To: **Environmental Health - Planning consultation**

Application No: WA/30/20/PL

Site Address: Spindlewood Yapton Lane Walberton BN18 0AS

Description of Works: Demolition of existing dwelling & erection of 8 No. dwellings with associated landscaping, parking & works. This application is a Departure from the Development Plan.

Drawing No.
DPA 02

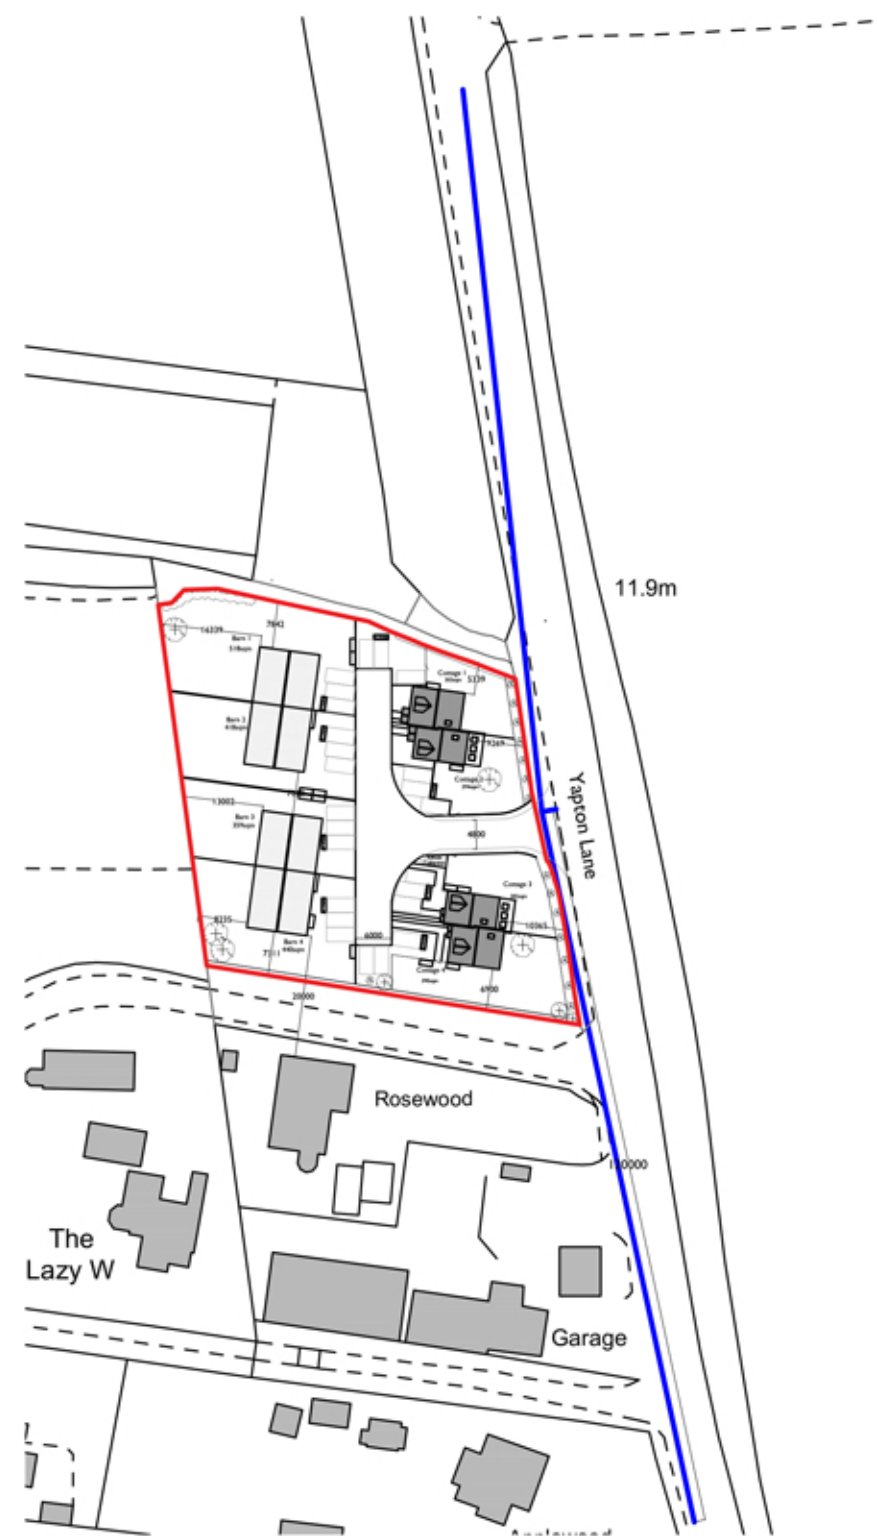
- I was pleased to see that of the 24 parking spaces provided, 8 will have electric car charging points – this should be at least one per property.
- I have concerns that future occupiers of the development may be affected by noise from the nearby nursery. Other similar sites have been affected by traffic noise from vehicles arriving and leaving the site and noise from loading and unloading activities. I would therefore recommend the following condition;

Prior to the commencement of the development hereby approved, a scheme to demonstrate that the internal noise levels within the residential units will conform to the “Indoor ambient noise levels for dwellings” guideline values specified within Table 4 under section 7.7.2 of BS 8233:2014.

Details shall be compiled by a competent acoustician on sound insulation and noise reduction for buildings and shall be submitted to and approved in writing by the Local Planning Authority. The scheme should take into account the correct number of air changes required for noise affected rooms. The works specified in the approved scheme shall then be carried out in accordance with the approved details prior to occupation of the premises and be retained thereafter.
